# KITTITAS COUNTY

TO: All Staff  
FROM: Justin Turnbull, County Surveyor   
DATE: April 25, 2019  
SUBJECT: County Survey Review of Final Plat LPF-19-0003 (Palomino Fields – Div. 2)  
(2<sup>nd</sup> Review)

Surveyed by LMH Scale 1" = 300'
Drawn by Tml/FCS Sheet 1 of 5
Checked by FCS Project No. 18146

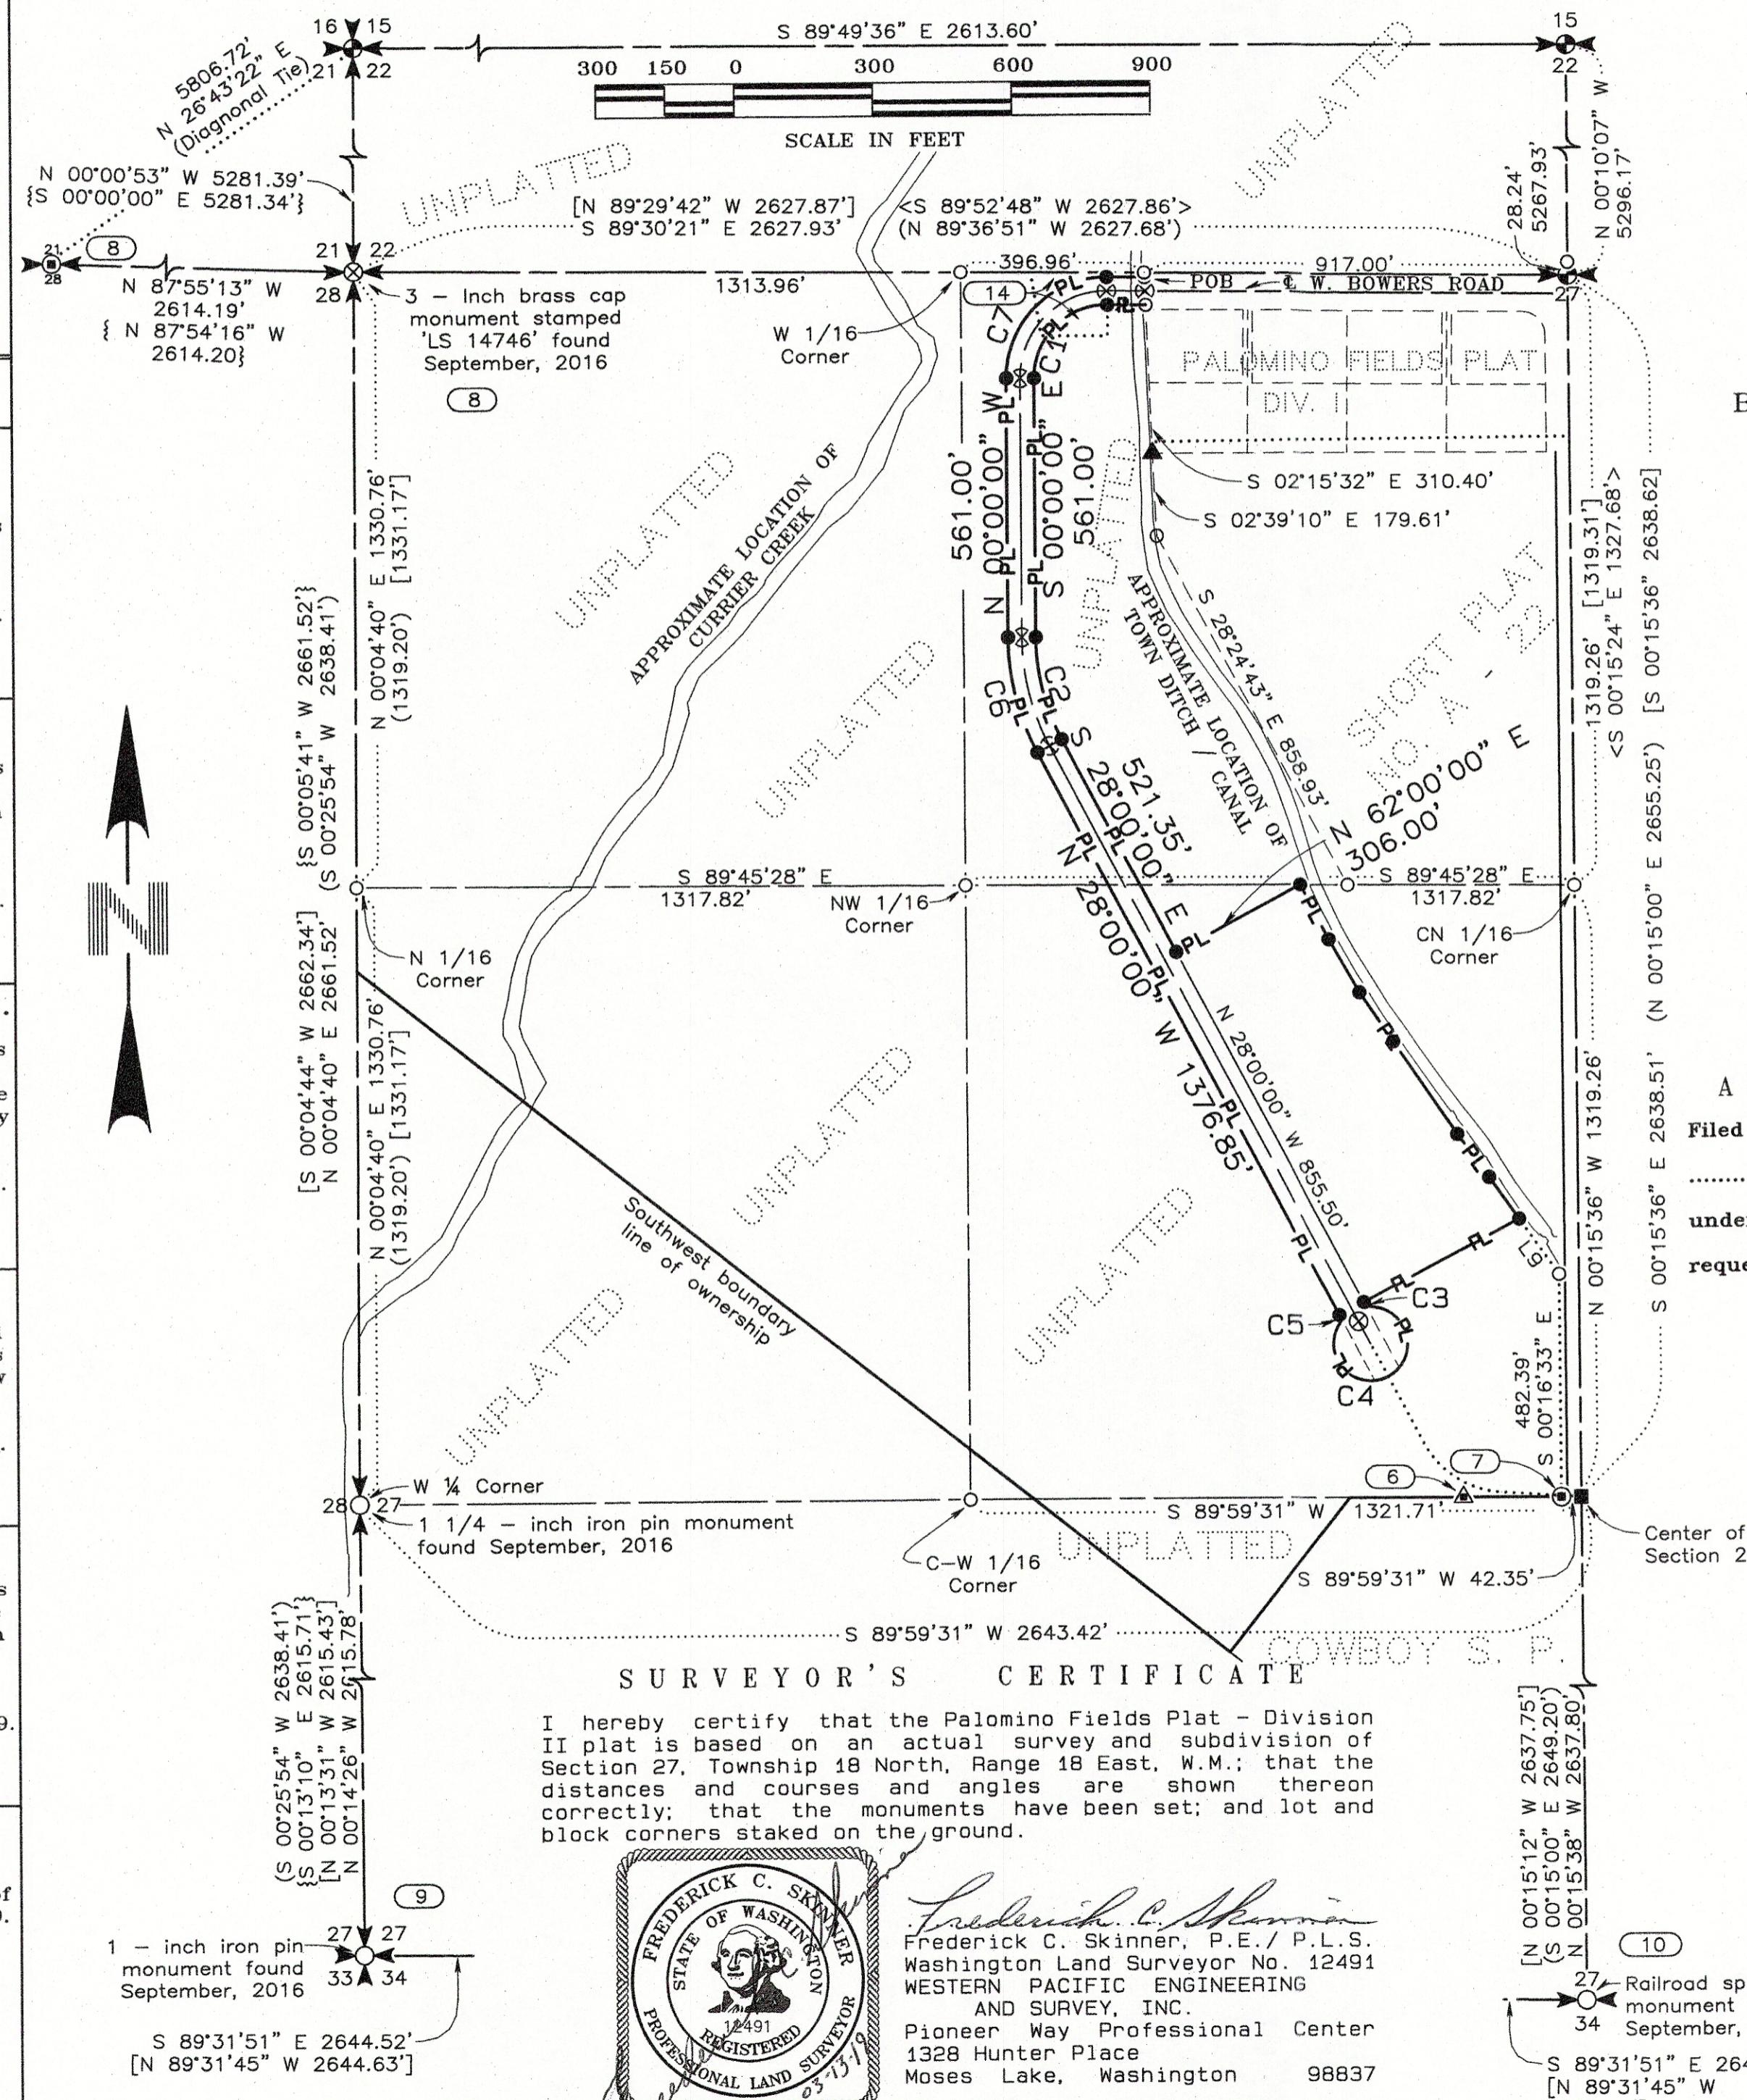
1. The South line of Tract D – dimension 458.32 is obscured.
2. The North line of Tract B – dimension 396.96 is obscured.
3. The North line of Section 27 – dimension 2627.68 is obscured.
4. The South line of Tract C – dimension 480.82 is obscured.

Surveyed by LMH Scale 1" = 100'
Drawn by Tml/FCS Sheet 2 of 5
Checked by FCS Project No. 18146

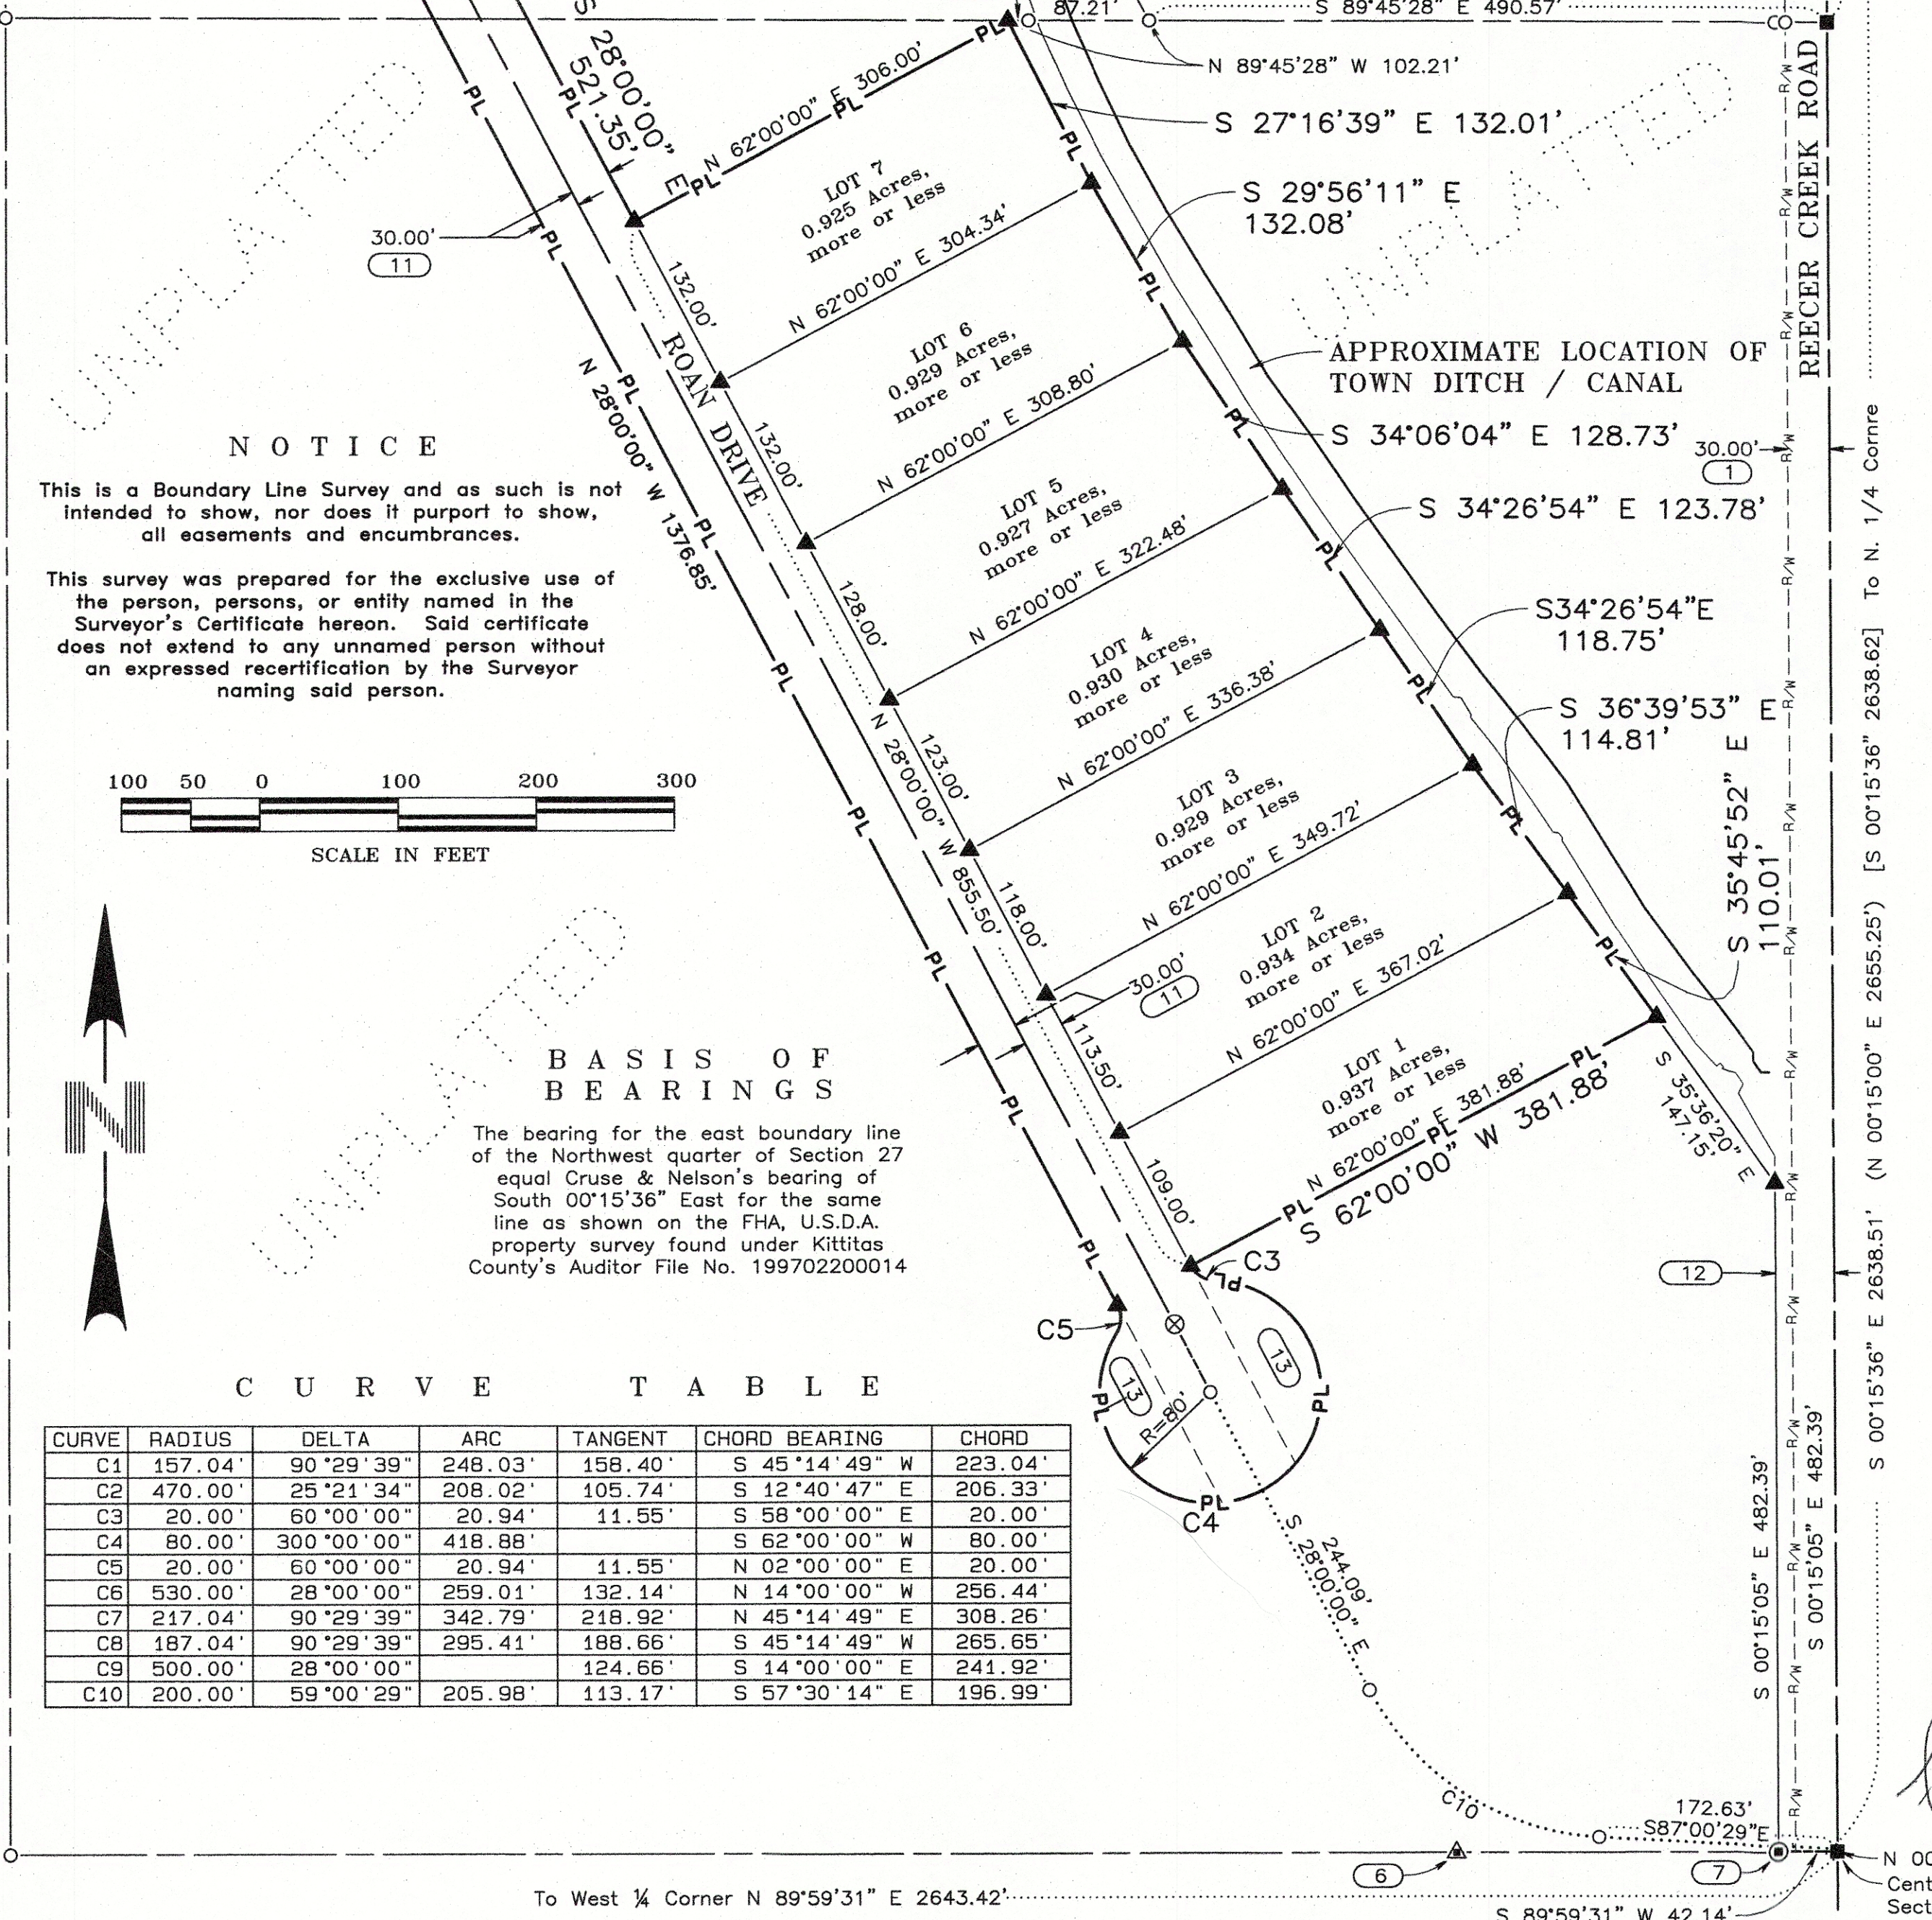
5. Spelling error “conre” on N-S center section line.
6. Spelling error “Dlitch” in town ditch description.
7. The Easement (Note 13) is an easement within the road right of way, rather than an easement within Tract D. While not incorrect, it is assumed that the purpose of the temporary easement is to return the land to private interest once the road completes a loop, and therefore not requiring the cul-de-sac.
8. The delineation of “N00°15'36"W, 1.82 is unclear is to what is being dimensioned.
9. Dimension C24 is obscured. (Also occurs on sheet 3)
